# Rezoning Transportation Analysis

Petition Number: 2023-134

Date	Description
11-21-23	First Review (NK)
12-20-23	Second Review (NK)

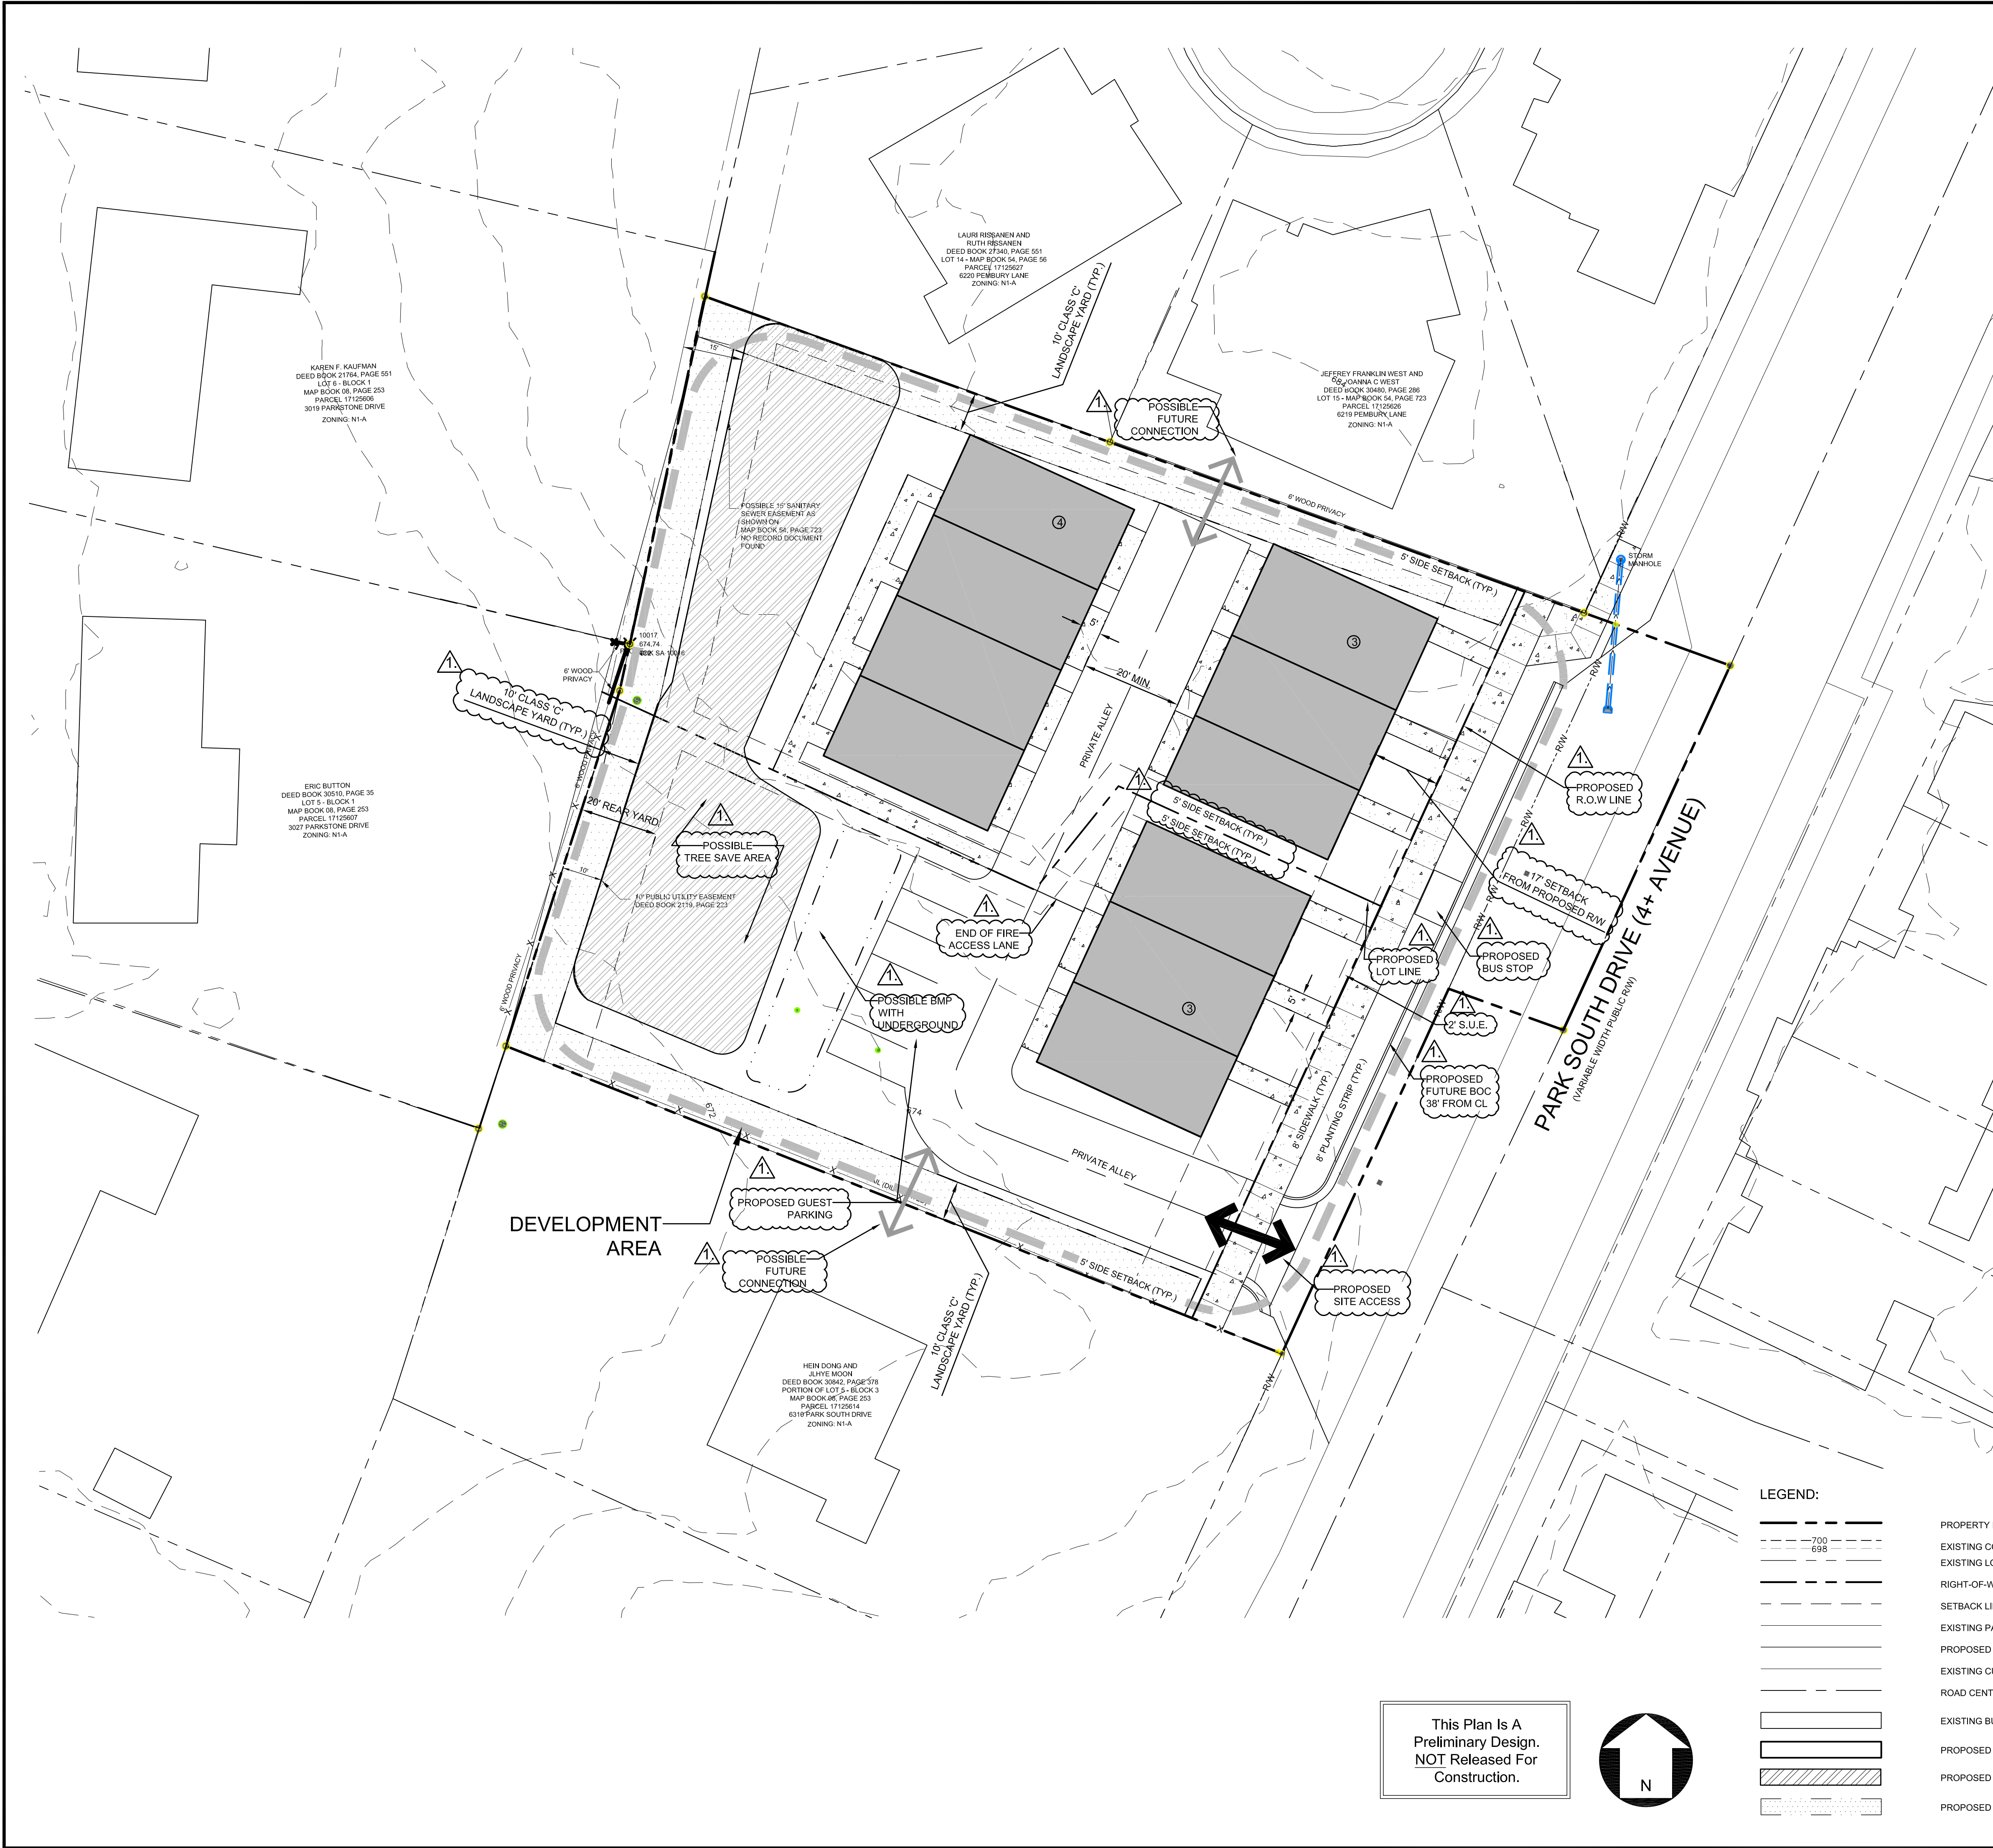
**Clarifying Comment 12/20/23:** Dimension for proposed BOC to CL needs to be shown on the plans as well as the buffered bike lane that is required per the Charlotte Street Map cross section.

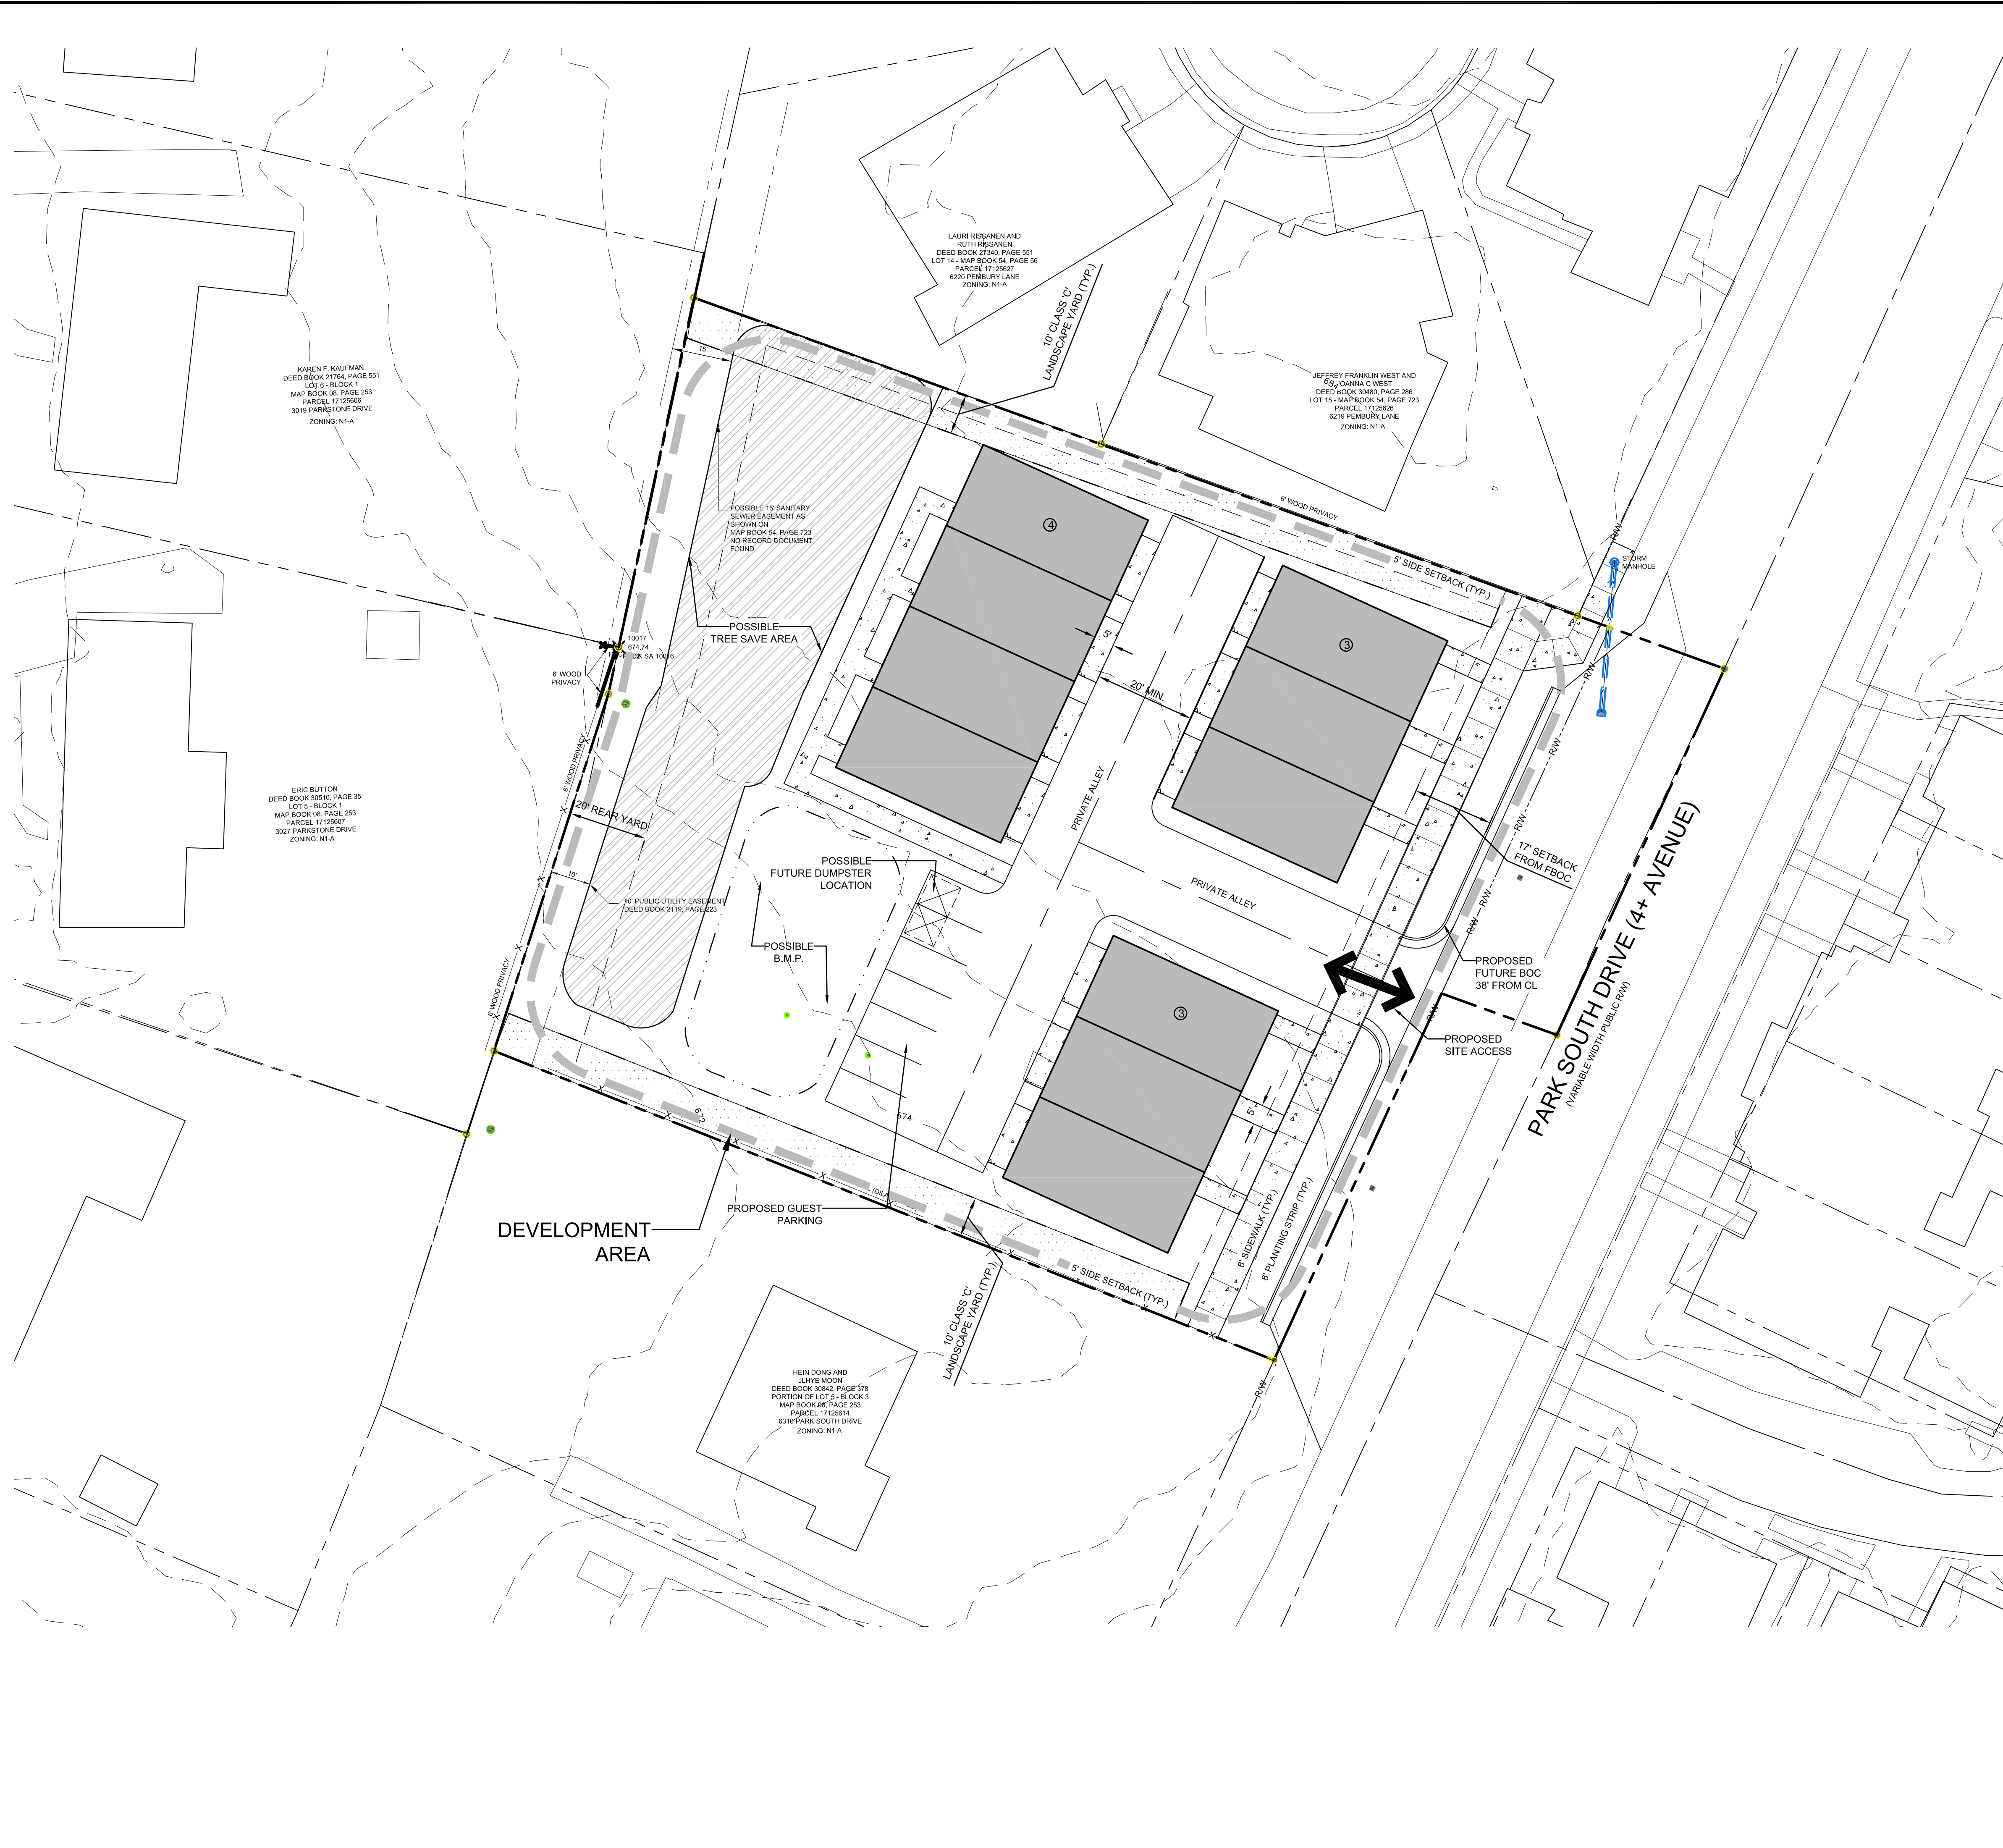
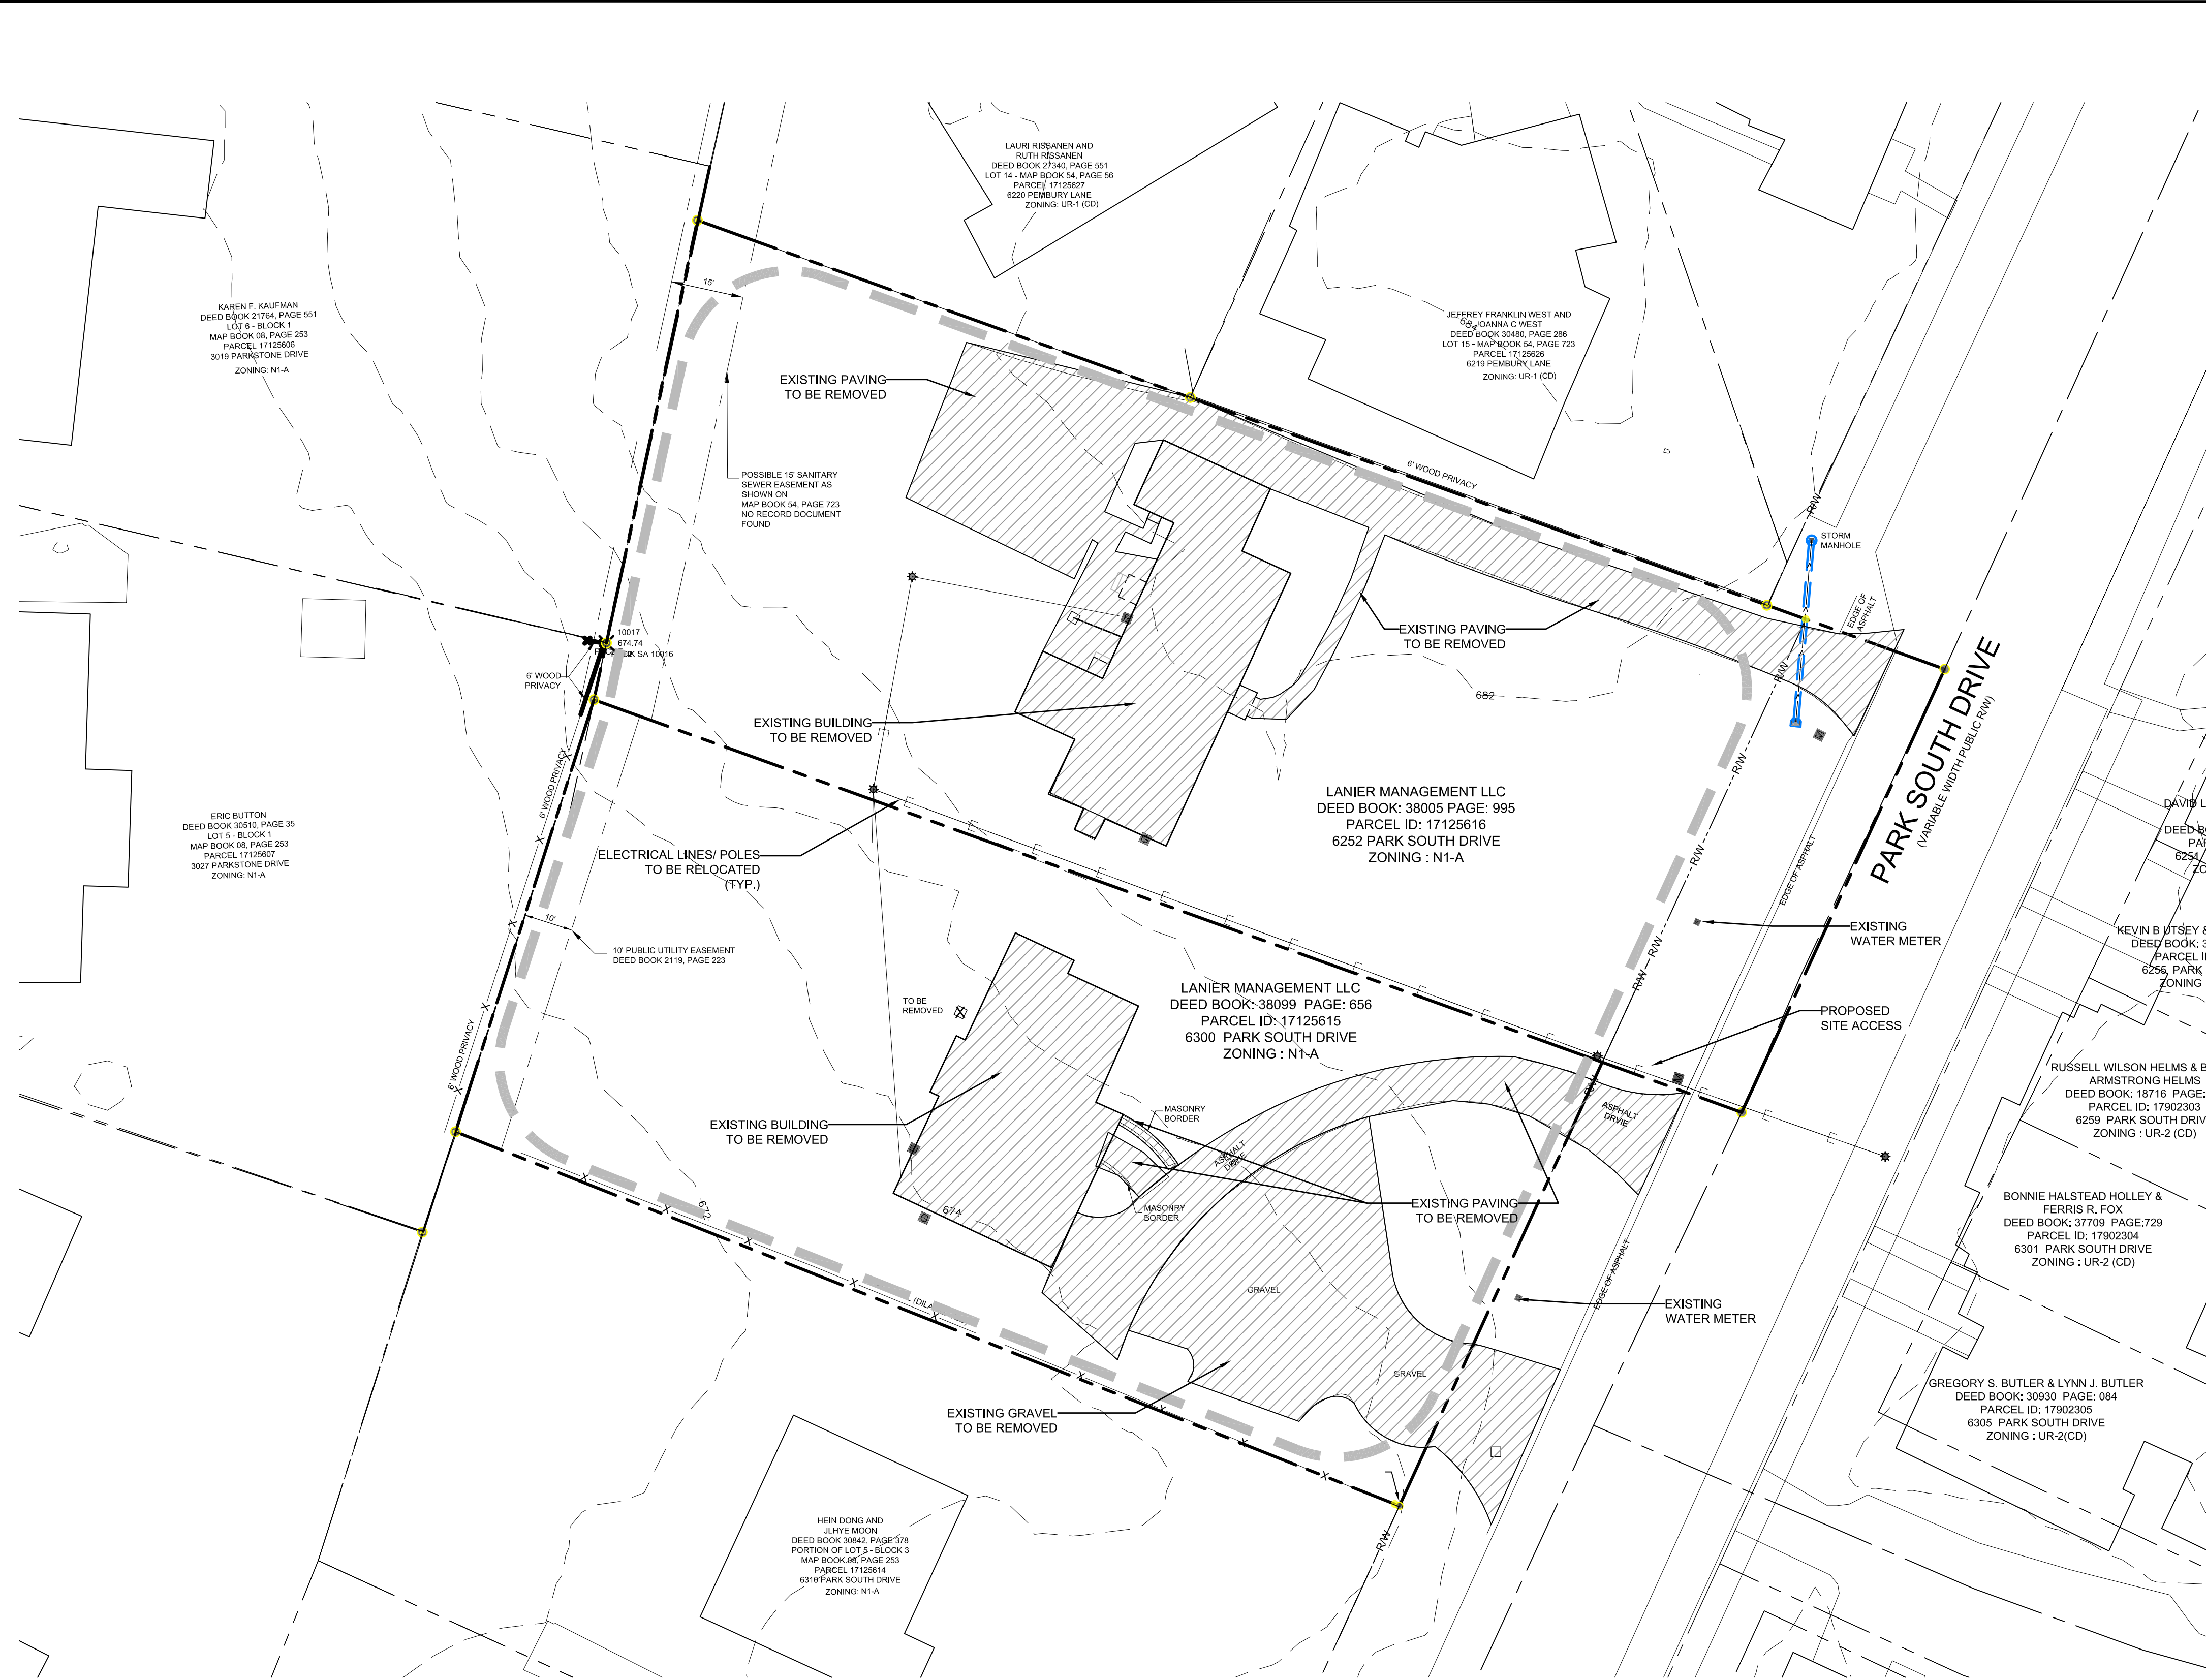
4. Revise site plan and conditional note(s) to commit to construct bicycle facilities by locating the curb and gutter 38' from the center line.
